Alan Varela, Director

June 18, 2025

**Re: Primrose School at 4550 Paradise Blvd NW
Erosion and Sediment Control Plan - C13E029
Engineer's Stamp Date (6/5/25) SWQ-2025-00034**

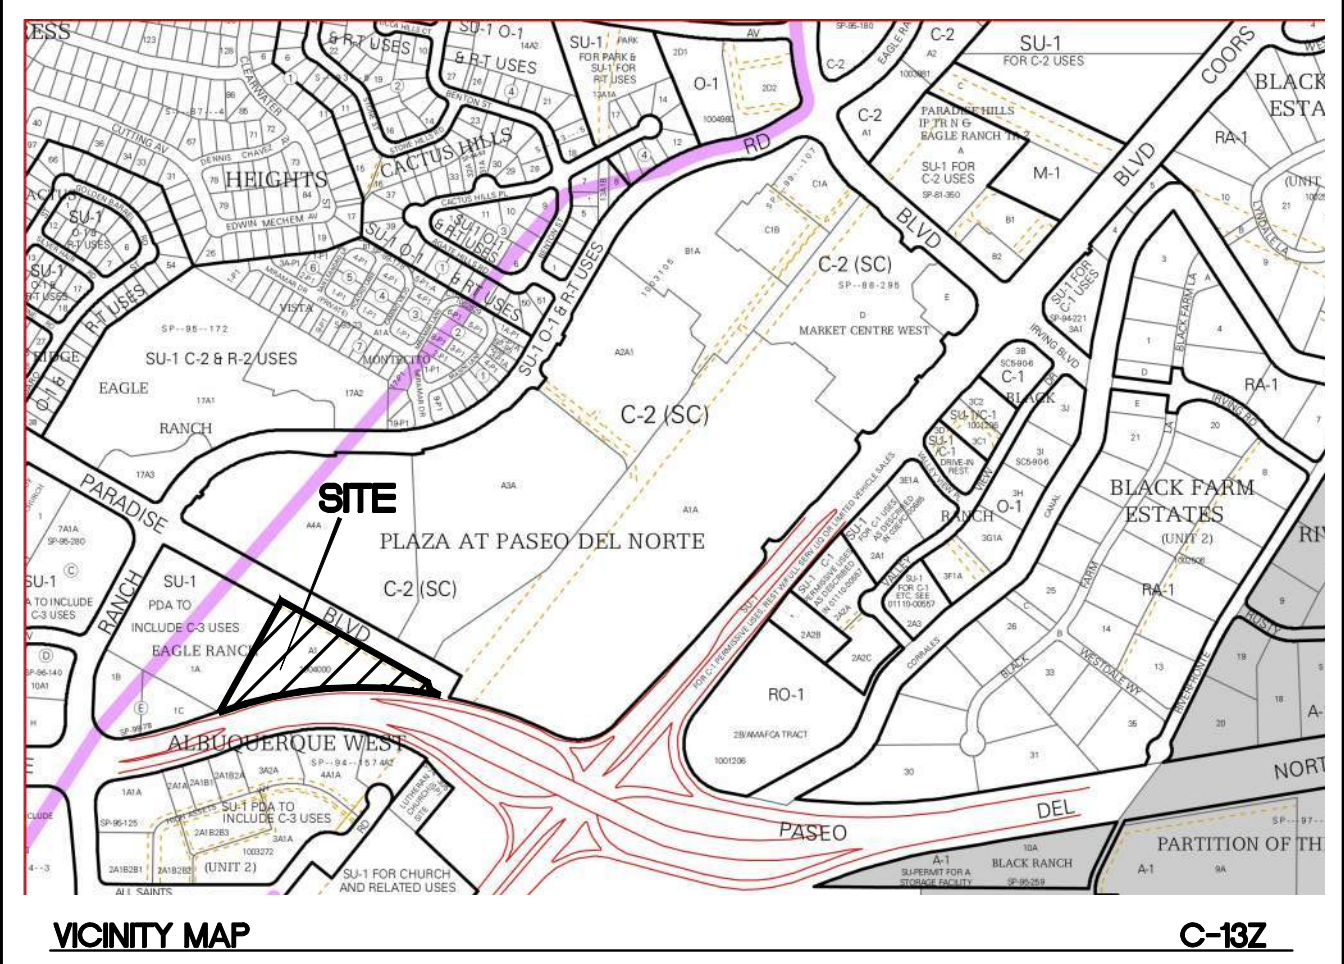
1. The limits of disturbance and area of disturbance must be modified to include the Work Order (WO) improvements in the public right-of-way north and south of this site as shown on the map on sheet SW-1, as identified in the table on sheet SW-2, and the "Estimated area to be disturbed" on the NOI.

RONALD R. BOHANNAN P.E. #7868	PRIMROSE SCHOOL OF NW ALBUQUERQUE	DRAWN BY pm
	EROSION CONTROL DETAILS	DATE 6-5-25
	 TIERRA WEST, LLC 5571 MIDWAY PARK PL NE ALBUQUERQUE, NEW MEXICO 87109 (505) 858-3100 www.tierrowestllc.com	DRAWING
		SHEET # SW-3 JOB # 2017092

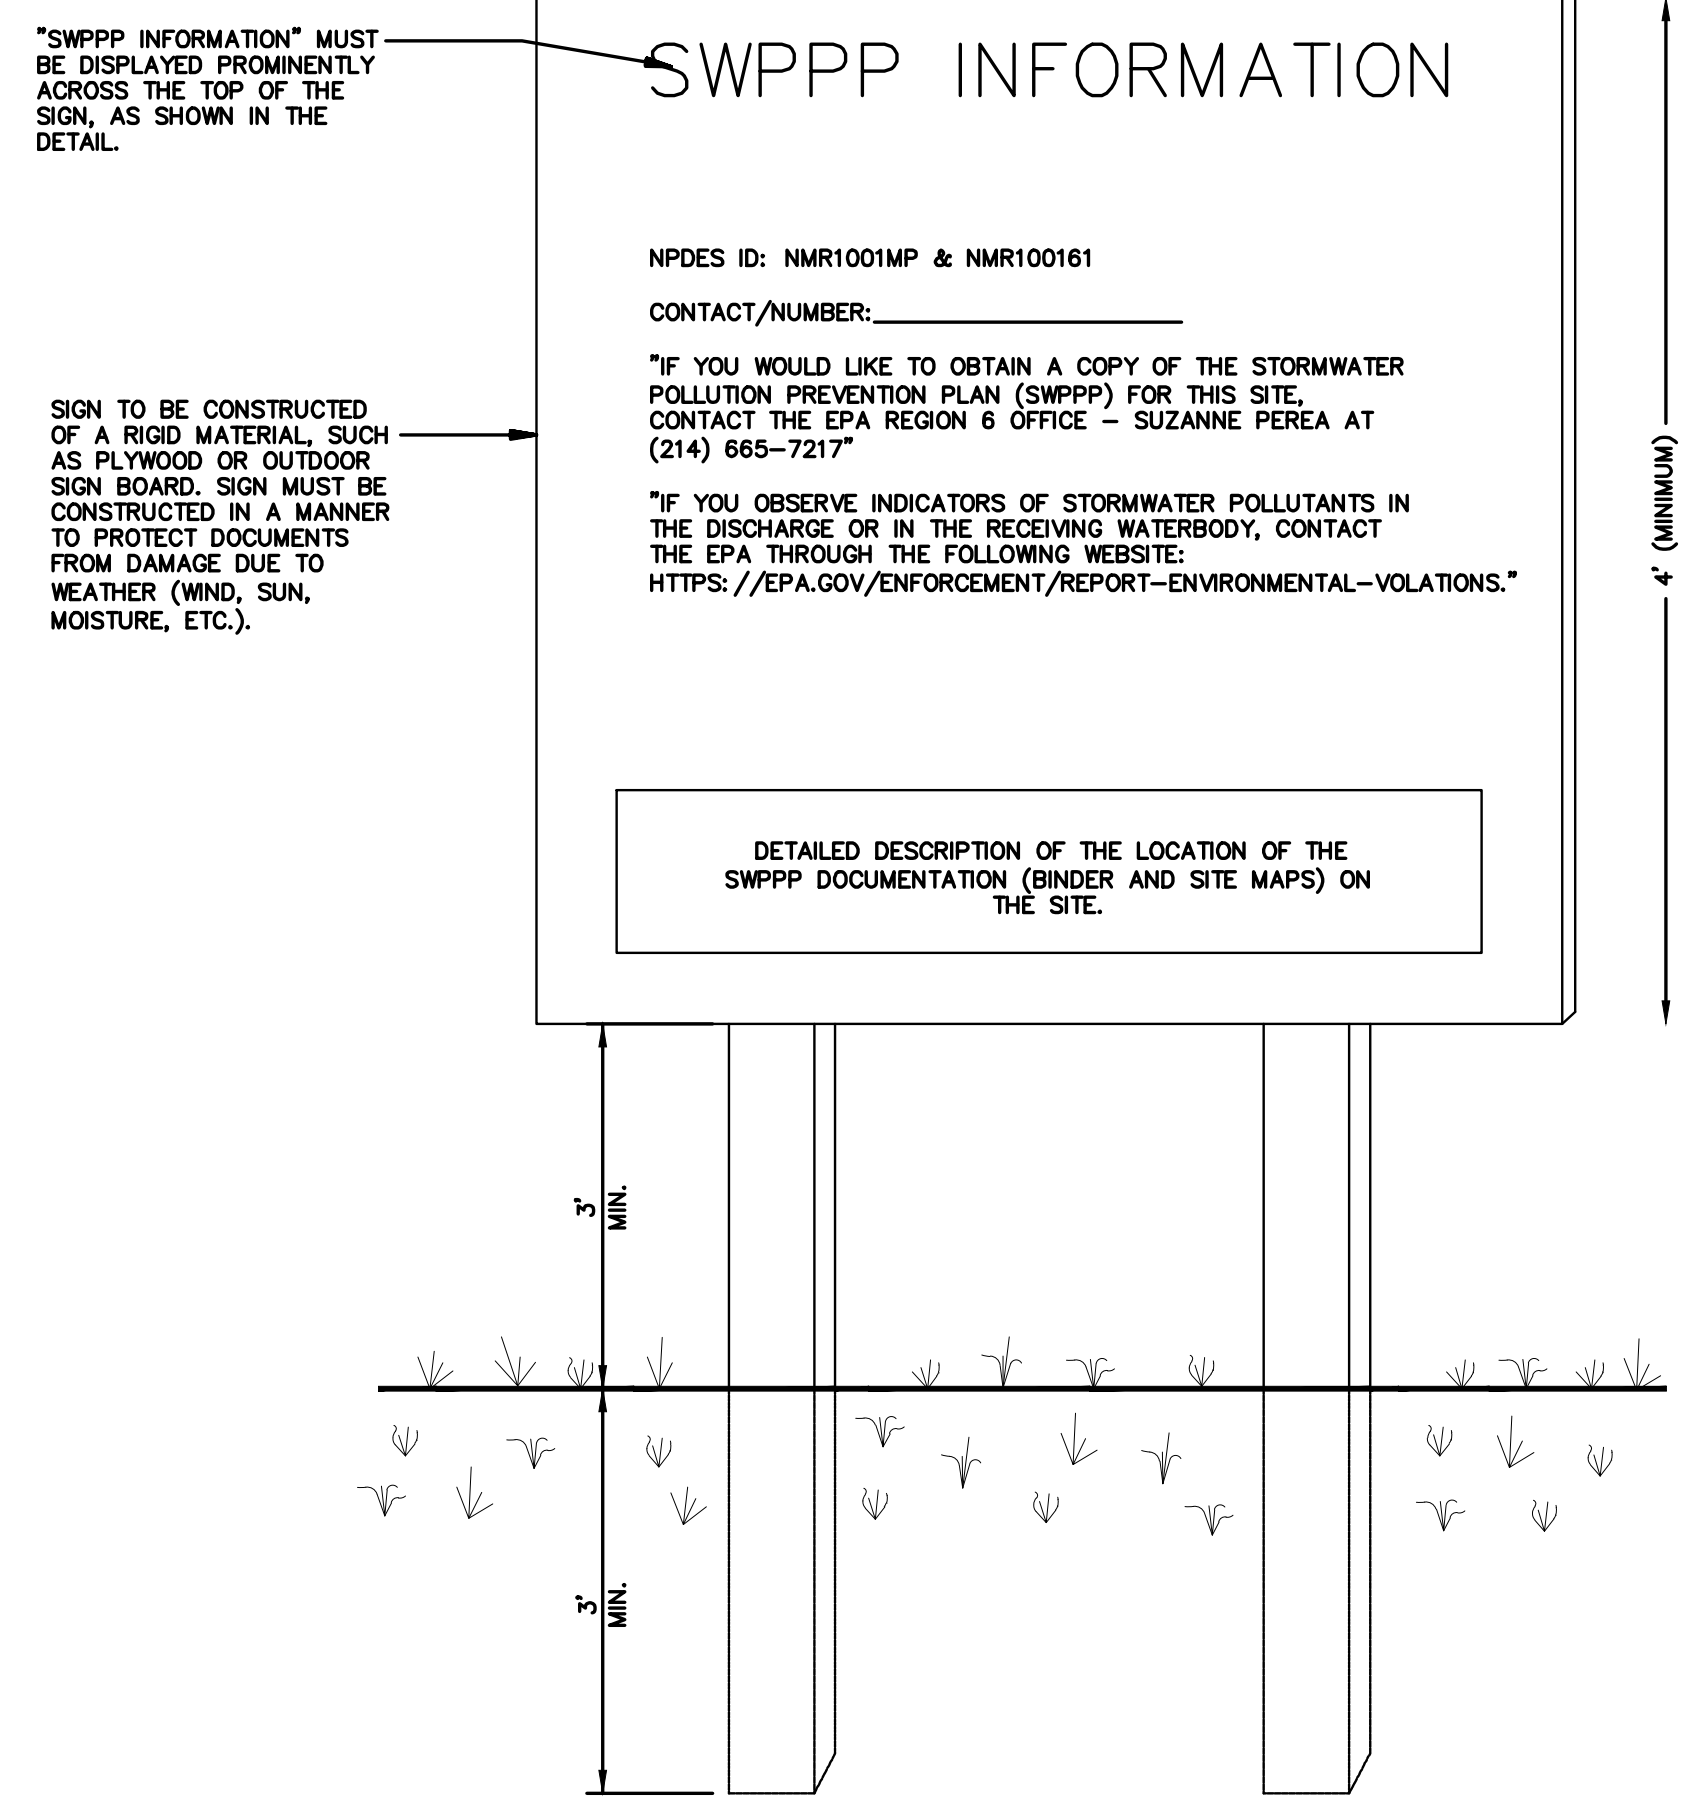
2. It appears that the ST is undersized. Provide design calculations and specifications for the temporary Sediment Trap per CGP 2.2.12.c. If a retaining wall is required to construct the south embankment of the ST and the outlet, provide construction specifications and clearly identify the wall as one of the first items of construction before clearing and grading. Clearly label the contours and dimensions of the temporary ST. Provide hydraulic calculations, sections, and construction specifications for the temporary non-erosive outlet structure per CGP 2.2.12. d and e.
